MMO Reference: DCO/2019/00004
Planning Inspectorate Reference: EN010109

Planning Act 2008: Proposed Sheringham Shoal Offshore Wind Farm Extension Project (SEP) and Dudgeon Offshore Wind Farm Extension Project (DEP).

This document comprises the Marine Management Organisation's ("MMO") initial comments in respect of the above Development Consent Order application ("DCO Application") in the form of a relevant representation.

Sheet 6 of 6

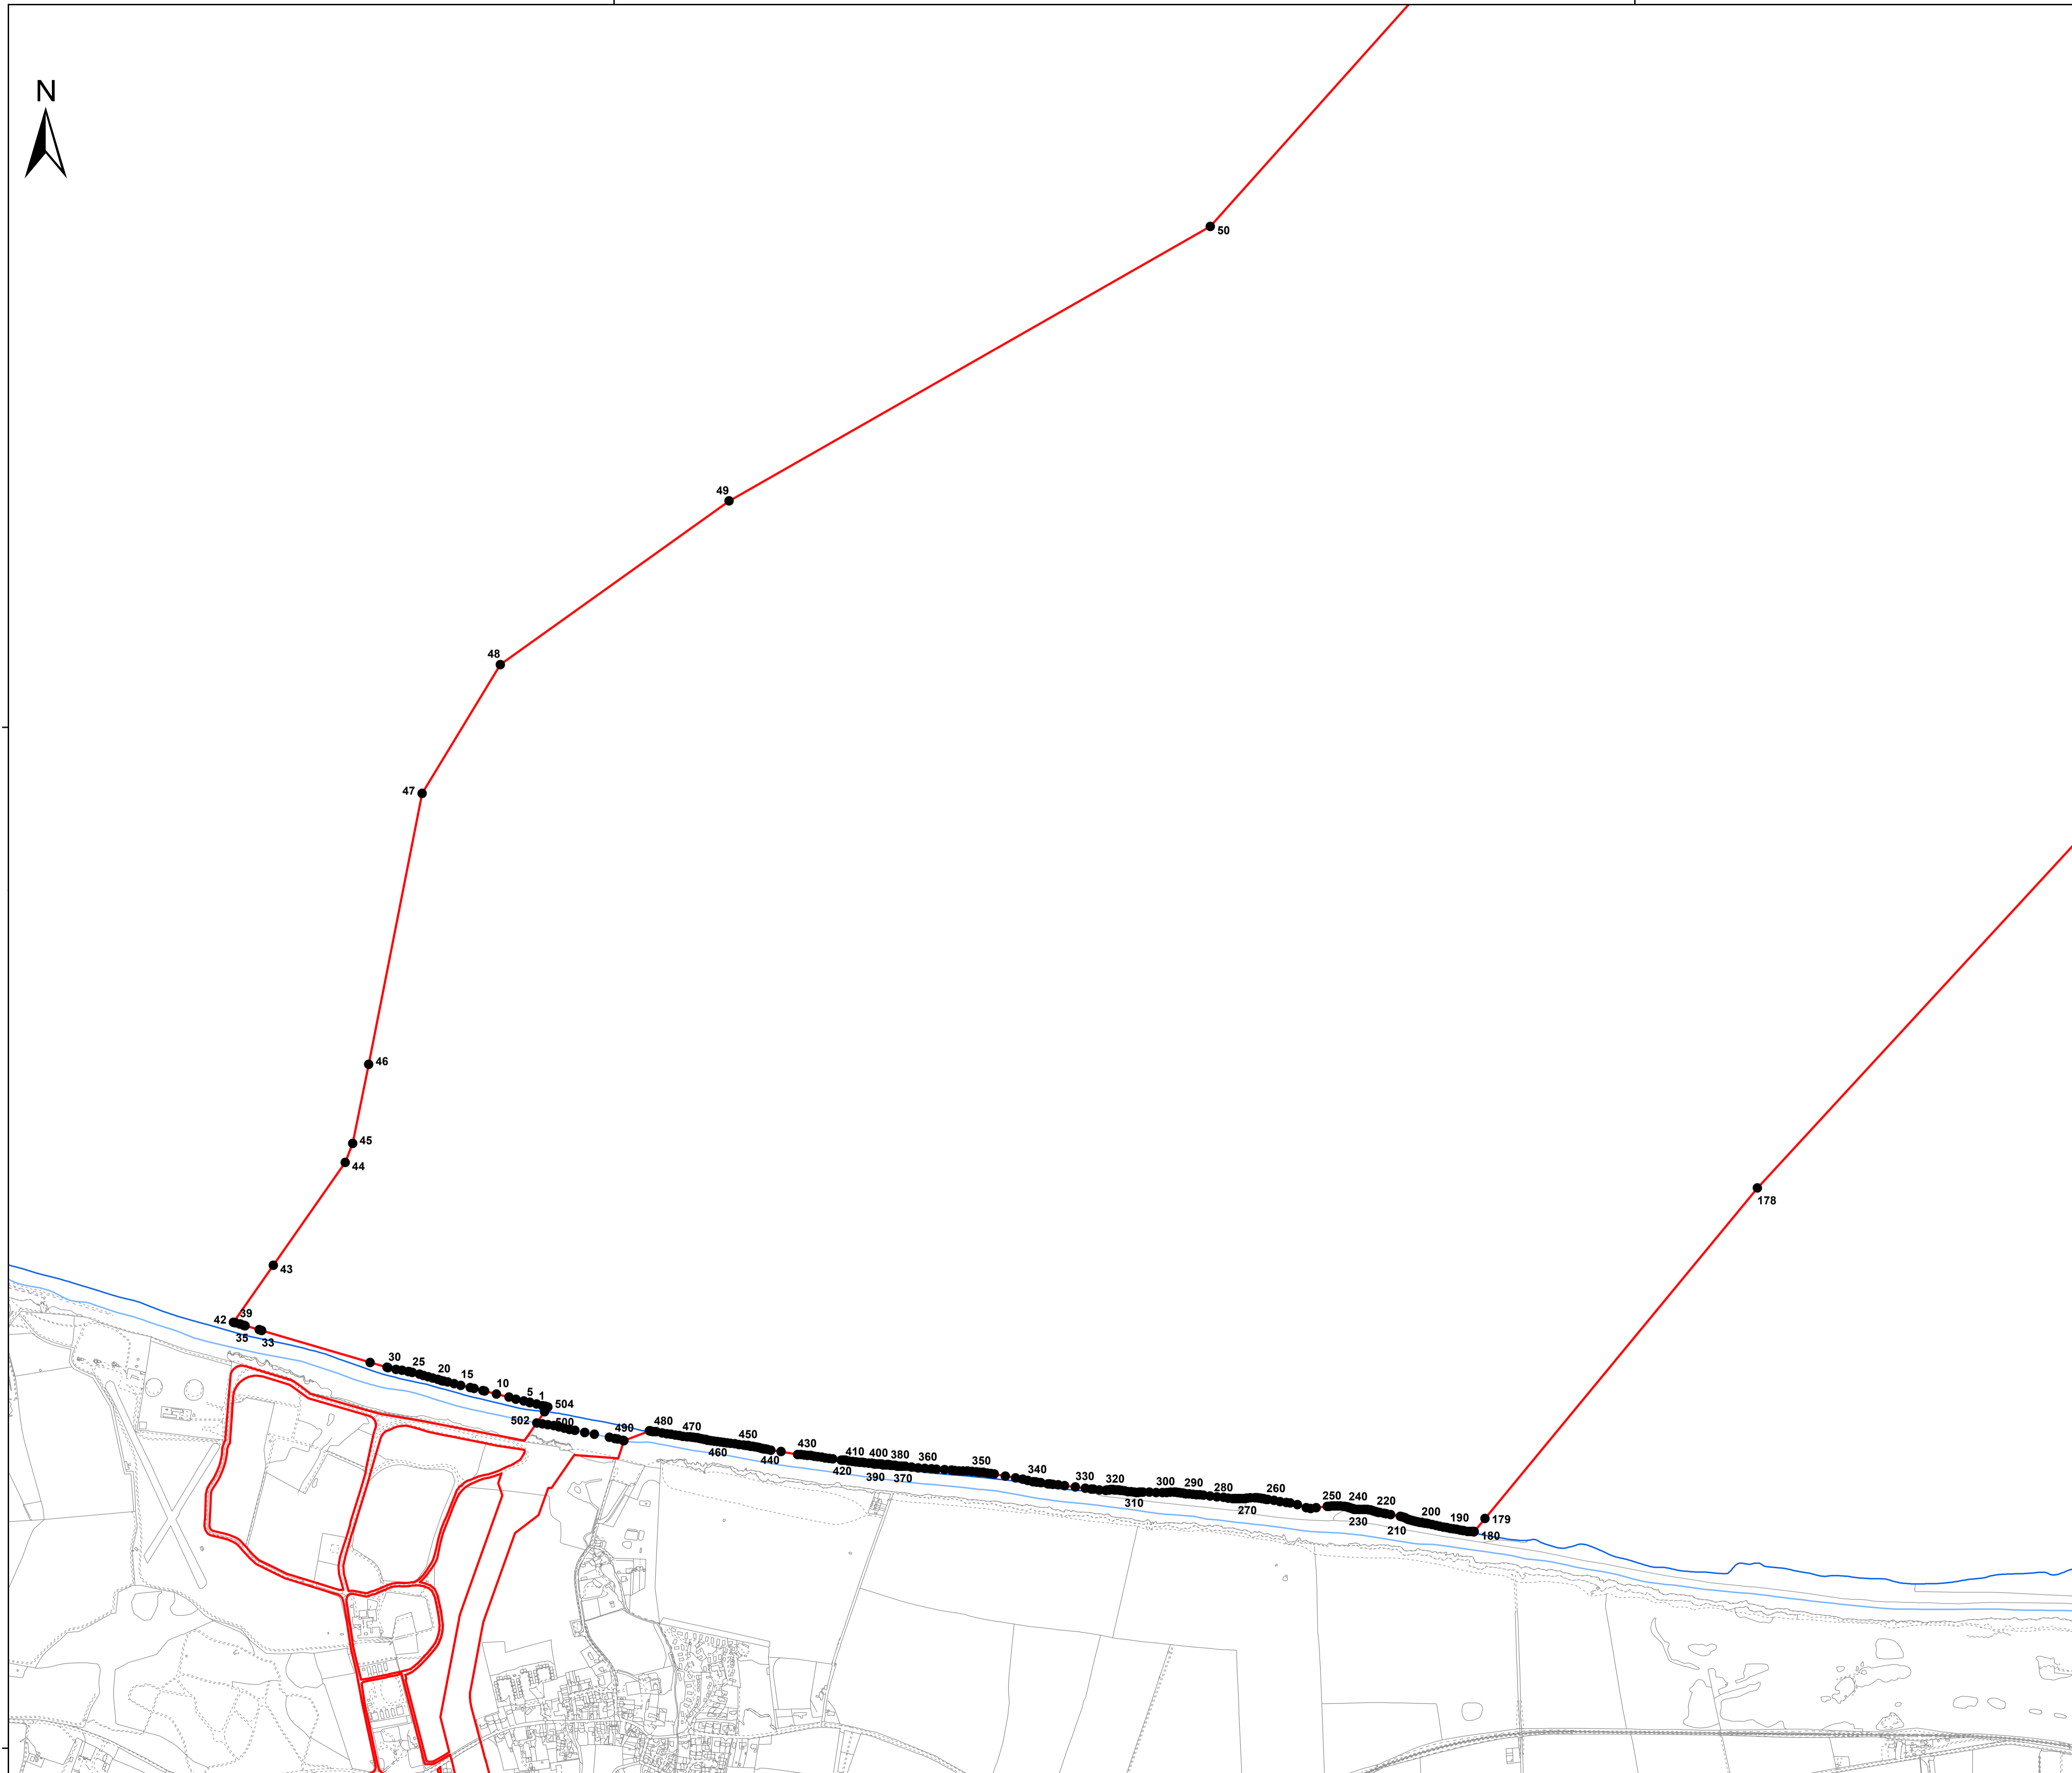
3.7.39 *Part 1 (5)* – The MMO note that the coordinates in schedule 13 appear to contain several errors where coordinates are incomplete (e.g. Row 176 and row 182 are missing the “15” from the latitude column). The MMO recommend that the DML’s are checked to ensure all coordinates are correct and that the onus is on the Applicant to ensure the coordinates accurately reflect the works area of the project.
